CITY OF ALBUQUERQUE

April 17, 2009

**Re: Van H. Gilbert Office Addition, 2428 Baylor Dr. SE,
Certificate of Occupancy – Transportation Development
Engineer's Stamp dated 7-16-08 (M16-D012)
Certification dated 02-06-09**

**Re: Van H. Gilbert Architect Studio Office Addition, 2428 Baylor Dr. SE,
Approval of Permanent Certificate of Occupancy, (M-16/D012)
Engineer's Stamp Date: 04-11-08
Certification Stamp Date: 4-10-09**

SECTION D-D (TYP.)
NTS

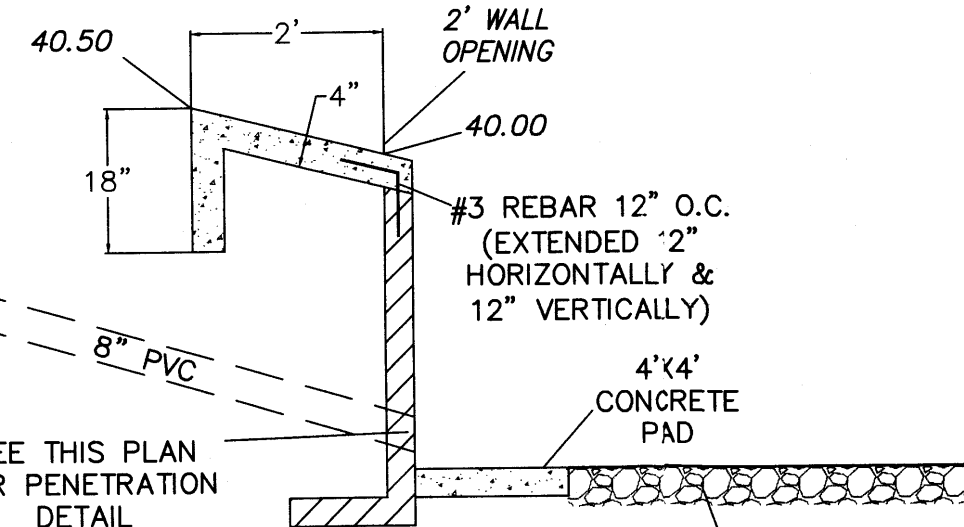
- Section A-A:
 - Provide details of how the rundown channels and the Drain Pipes will pass through the R.R. Tie Retaining walls.
 - Section D-D: The section appears to be reversed from the section cut in the plan view.

- Section D-D: Show in the section where the channel intercepts the lowest terrace wall.
 - Section D-D: Show the 6" layer of rock in the pond bottom.
- Channel Section: Provide specified channel dimensions, not just ranges.

- Section D-D section cut was corrected on the plans. Section D-D was also modified to show the new retaining wall. The 6" layer of rock is shown.
 - Channel Section was eliminated from the plans. The runoff will flow over the wall onto a proposed 4'x4' concrete apron.
 - Section F-F was added to show the retaining wall at the pond and the extended stem wall. Dimensions from the retaining wall to the extended stem wall were added on the Section F-F and Section A-A. Concrete apron does not connect to the extended stem wall.
 - Concrete Apron Detail. Sections D-D and F-F both show how concrete apron ties into the retaining wall.
- Please contact me if there are any questions or concerns regarding this submittal.

SECTION A-A
NTS

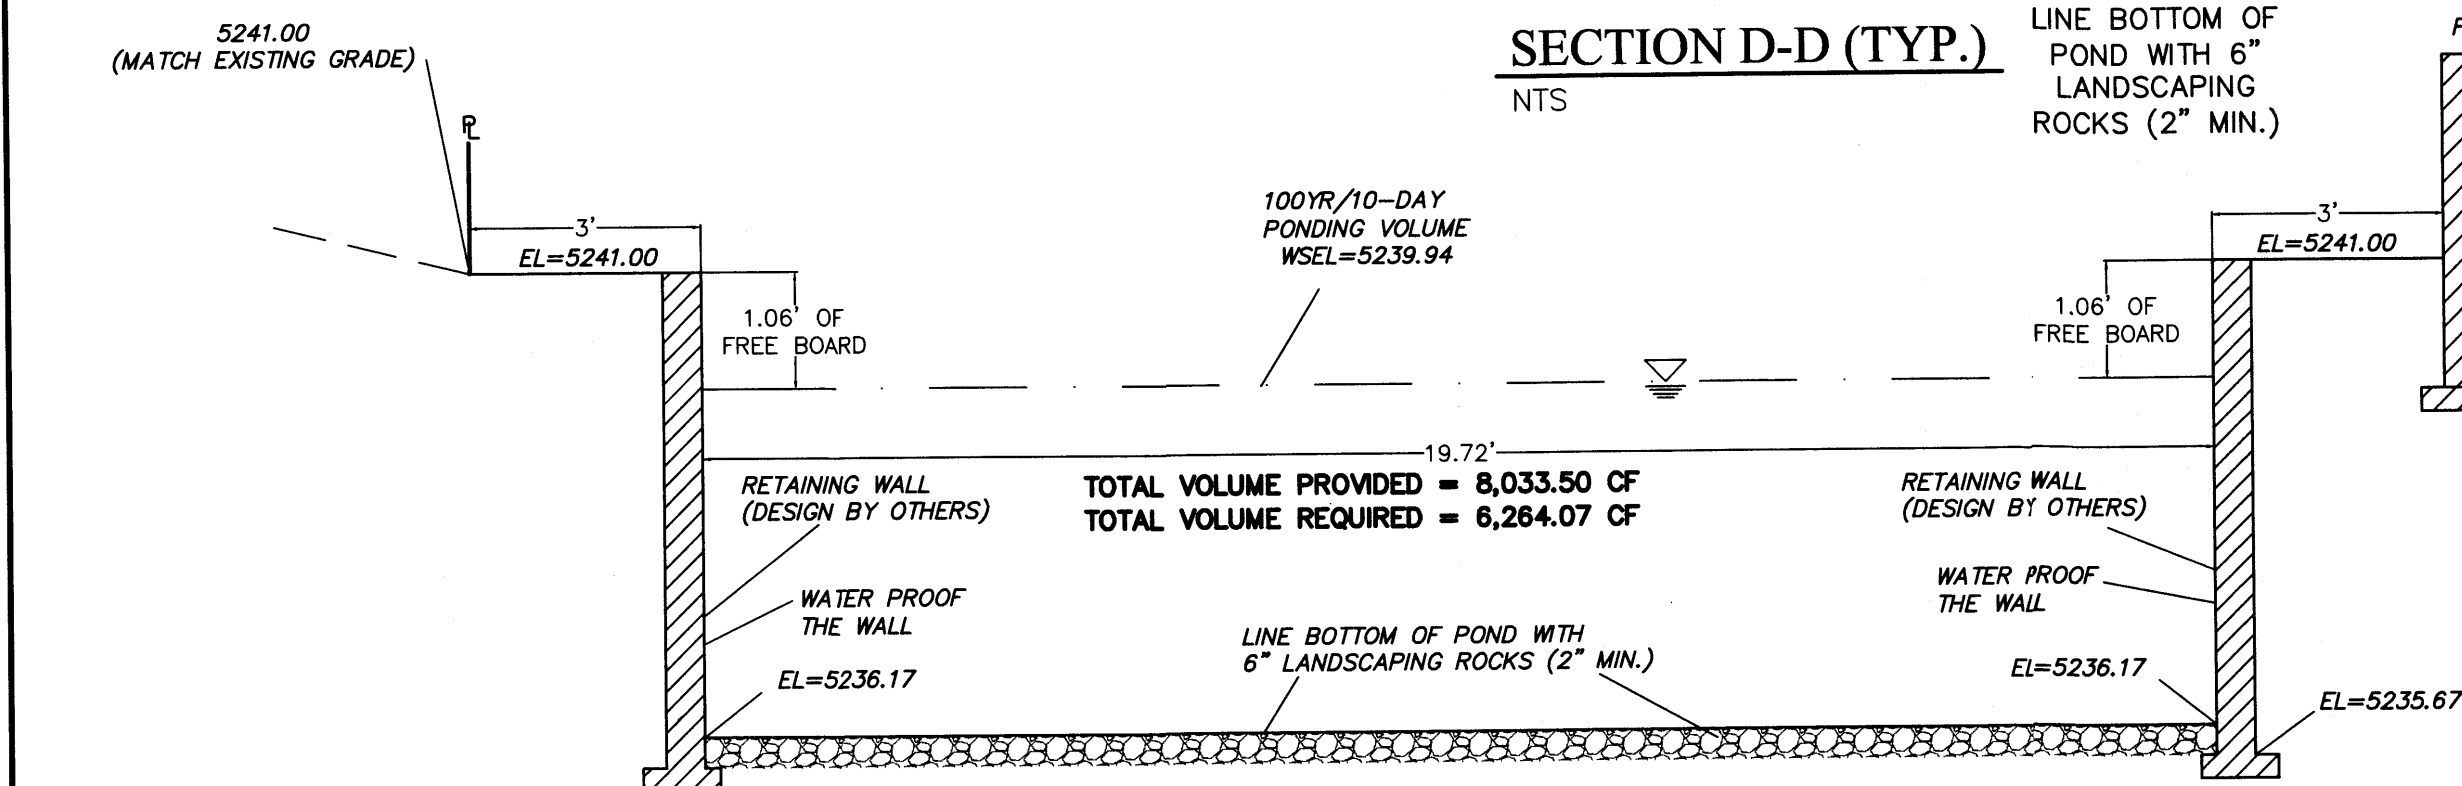
- The retention pond needs to have at least 12" of freeboard above the 100-year, 10-day water surface level. Calculations provided indicate freeboard will be less than 1-3/4". Show the 100-yr/10-day water surface on Section A-A and provide 12" minimum freeboard.

- Section A-A: With the grades provided in the Apron & Channel Detail it appears that the channel will be suspended above grade at the back of the 5239 Terrace Level.

- The retention pond was modified to have 1.06' of freeboard. The 100-year/10-day volume water surface elevation is shown on Section A-A. See attached revised calculations for the pond volume.

SECTION F-F
NTS

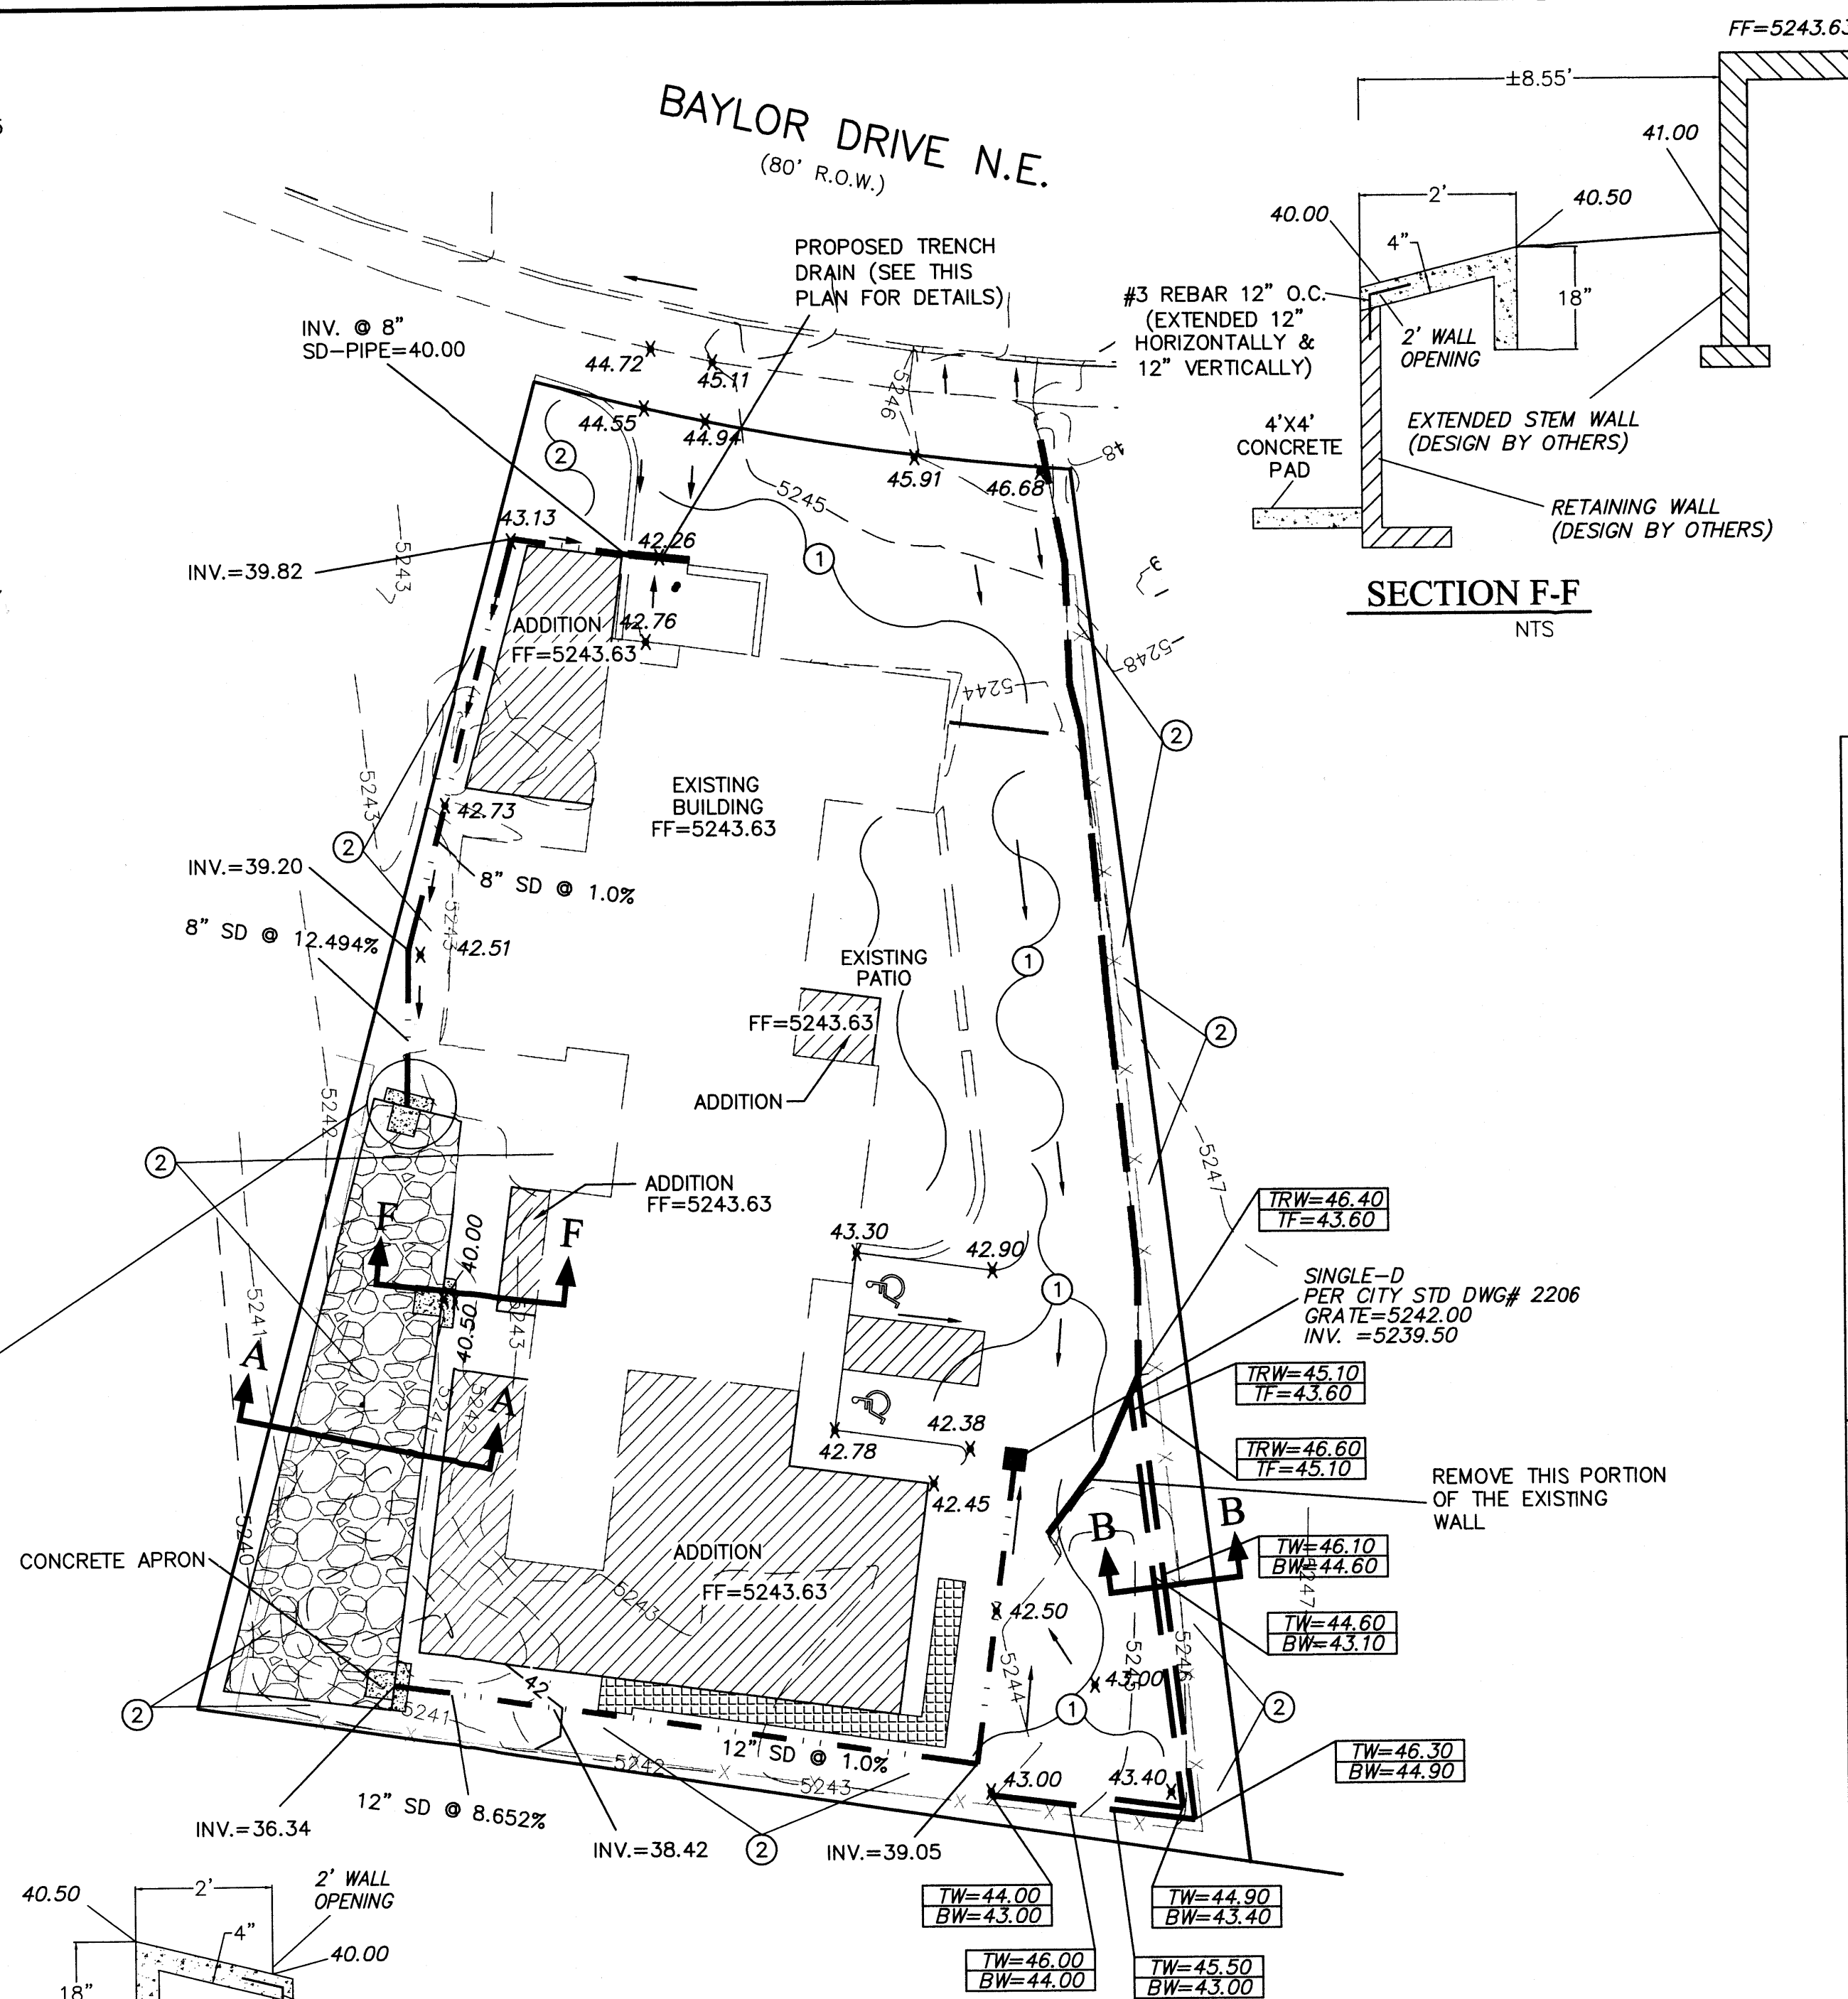
- Apron & Channel Detail: Provide a Section F-F cut parallel to D-D, outside the channel to show how the "Extended Stem Wall" fits with the R.R. Tie Retaining Wall and ties to the concrete apron slab; Show dimensions for the "Extended Stem Wall."
- Concrete Apron Detail: How does this tie or fit with the Retaining Wall?

SITE PLAN

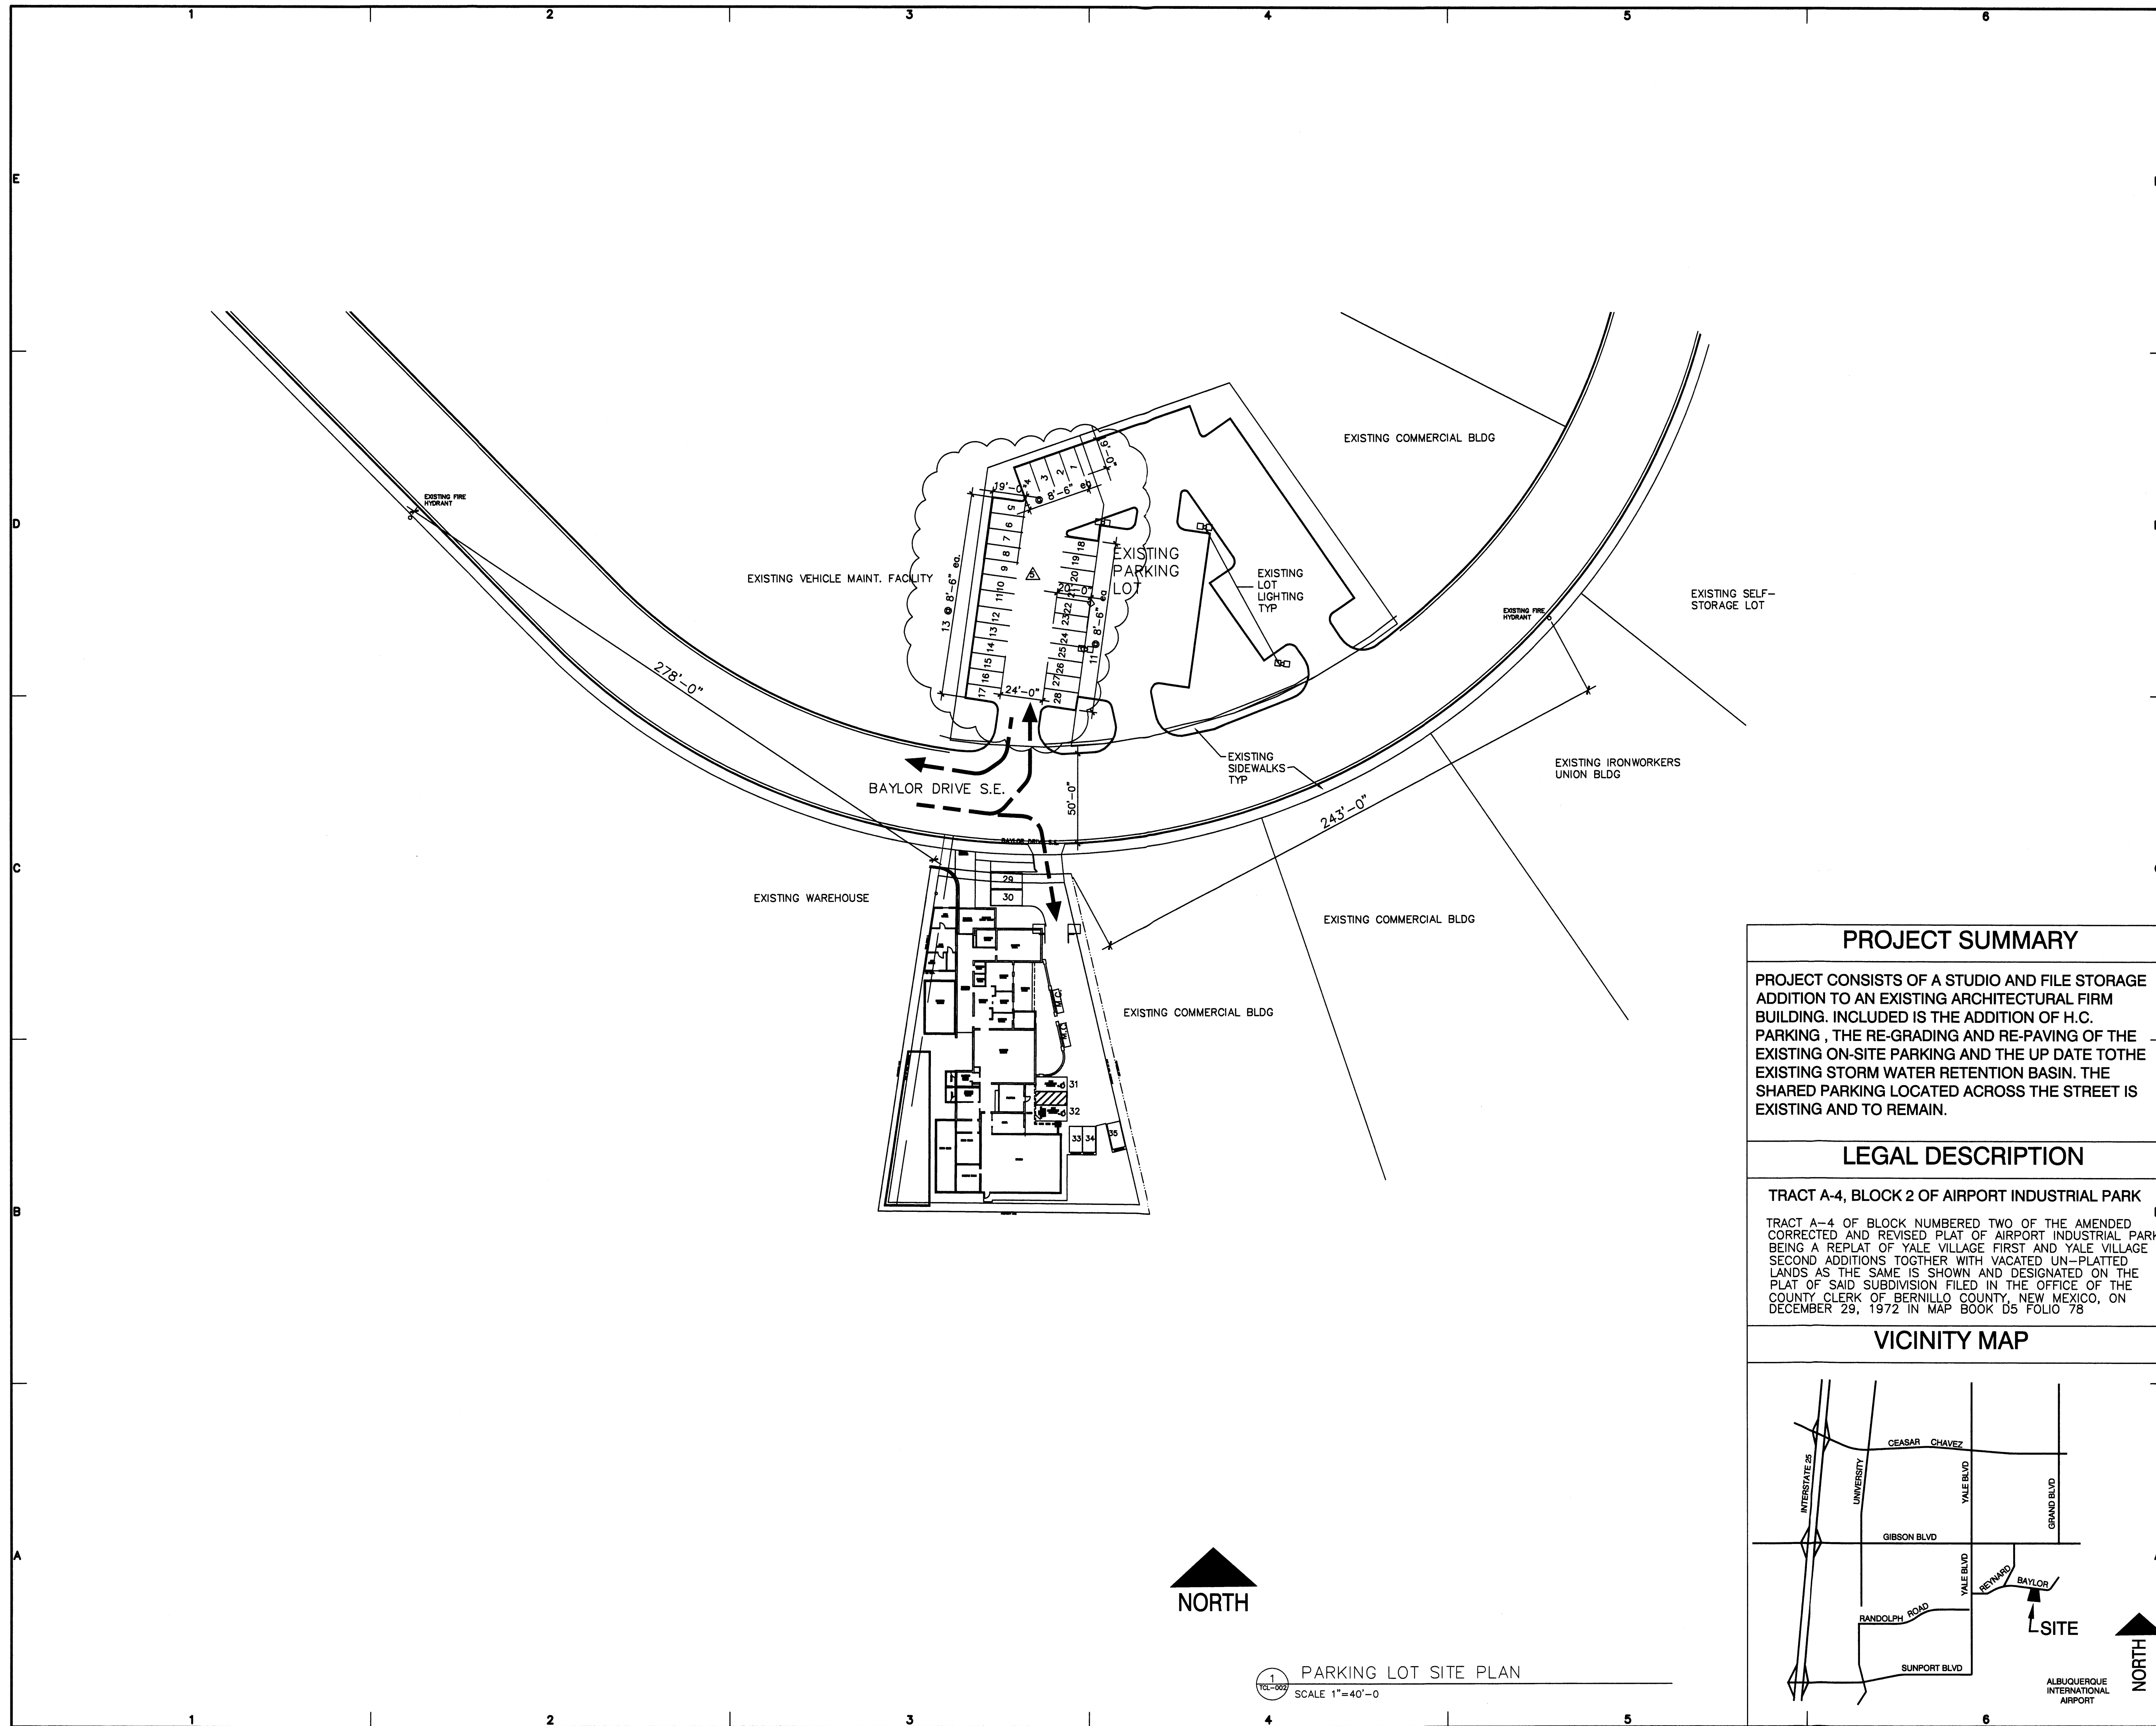
- 1 ✓ The traffic circulation layout must be stamped, signed, and dated by an engineer or architect licensed in the state of New Mexico.
- 2 ~~Provide a copy of the shared parking agreement with Lot # 11.~~
3. Please show a vicinity map on the plan.
- 4 ✓ A scale must be shown on the plan. Per the Development Process Manual, Chapter 27, Section 2, Part B.1, only the following scales may be used:
